DOC19/930439

13 November 2019

**The New Sydney Fish Market –Stage 2 (SSD 8925)
Advice on the Environmental Impact Statement**

Figure 1 Site Plan – Surrounding Receivers, NCAs and Noise Logging Locations

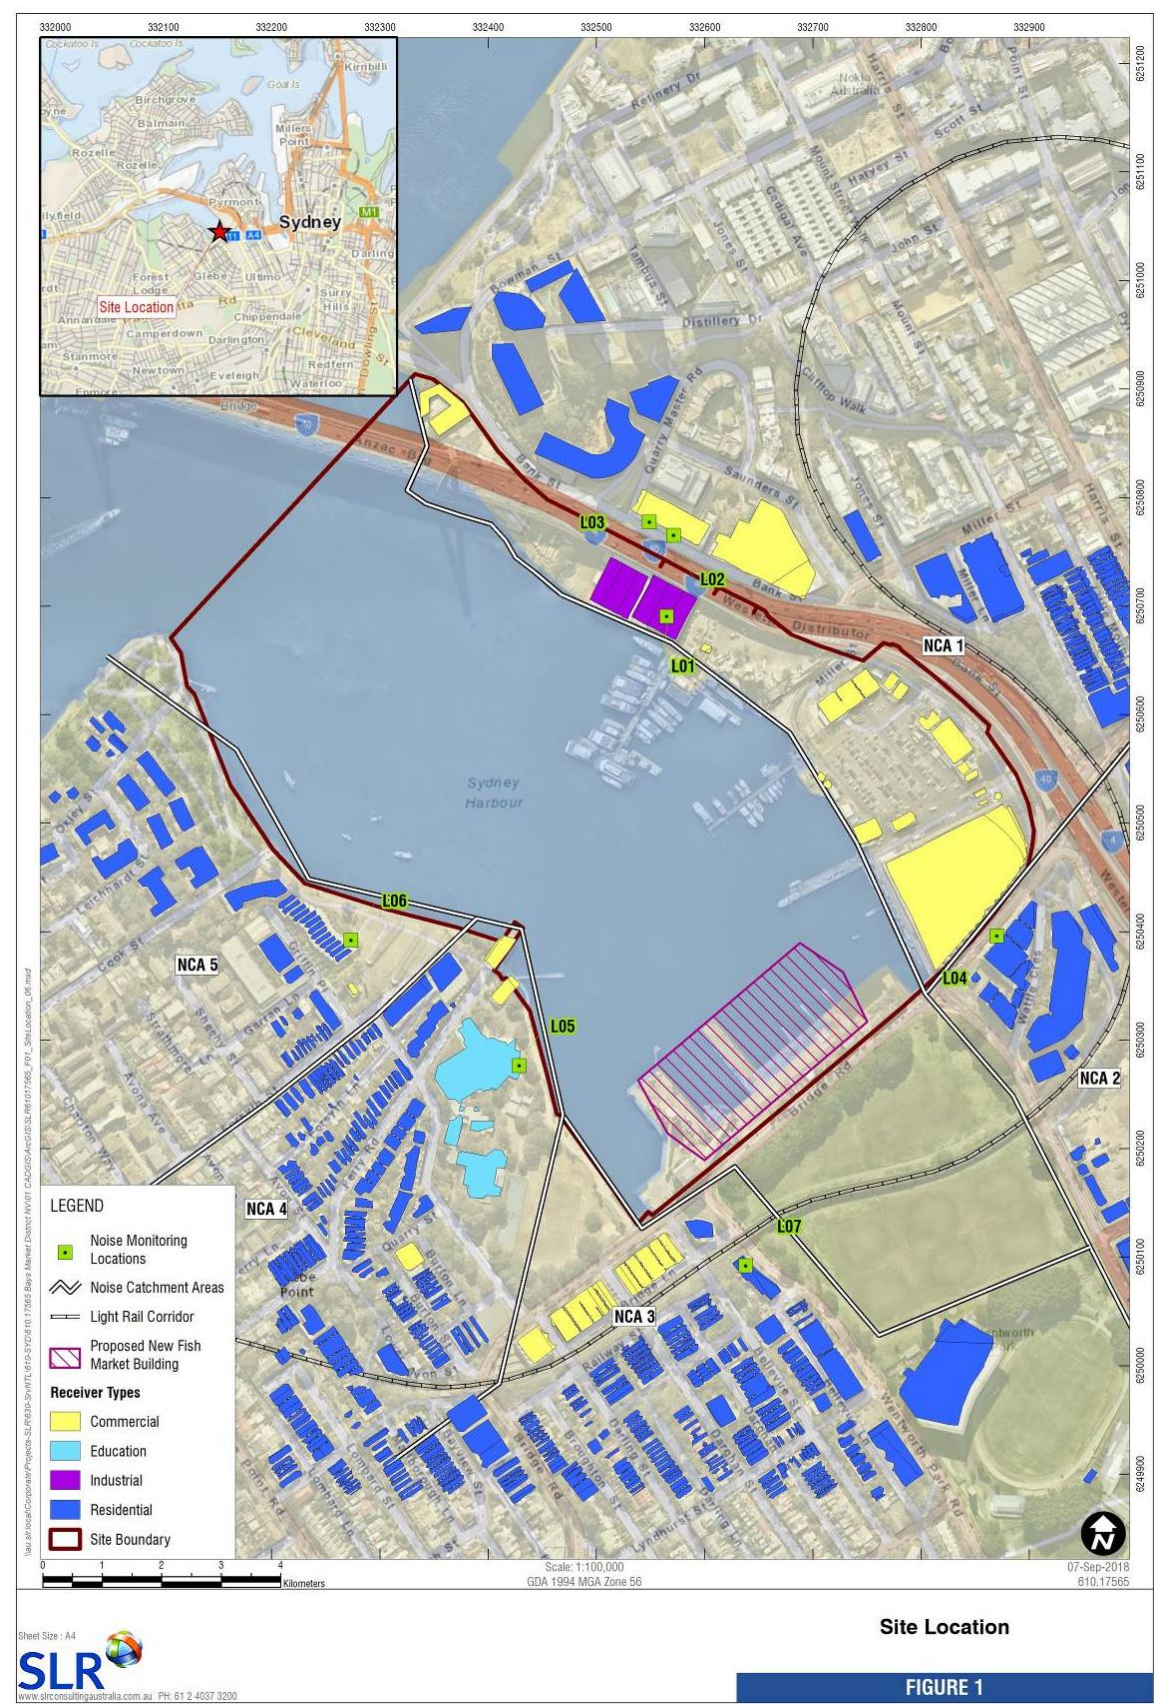
- The EPA notes that several logging locations utilised by SLR when determining the ambient background noise level for the purposes of generating project specific noise levels were not ideal. Specifically, it is noted that the unattended noise loggers at locations L.01, L.02, L.04 and possibly L.07 appear to be placed in highly reverberant noise environments (ie. under cover or near a façade). This is likely to raise the noise levels at the microphone, and as a result raise the project trigger noise levels. The NIA has not identified this as an issue and has not addressed the likely increase in recorded noise levels at these receivers. It is requested that clarification on the selection of monitoring locations and the effect the surrounding area had on the measured noise levels be sought.
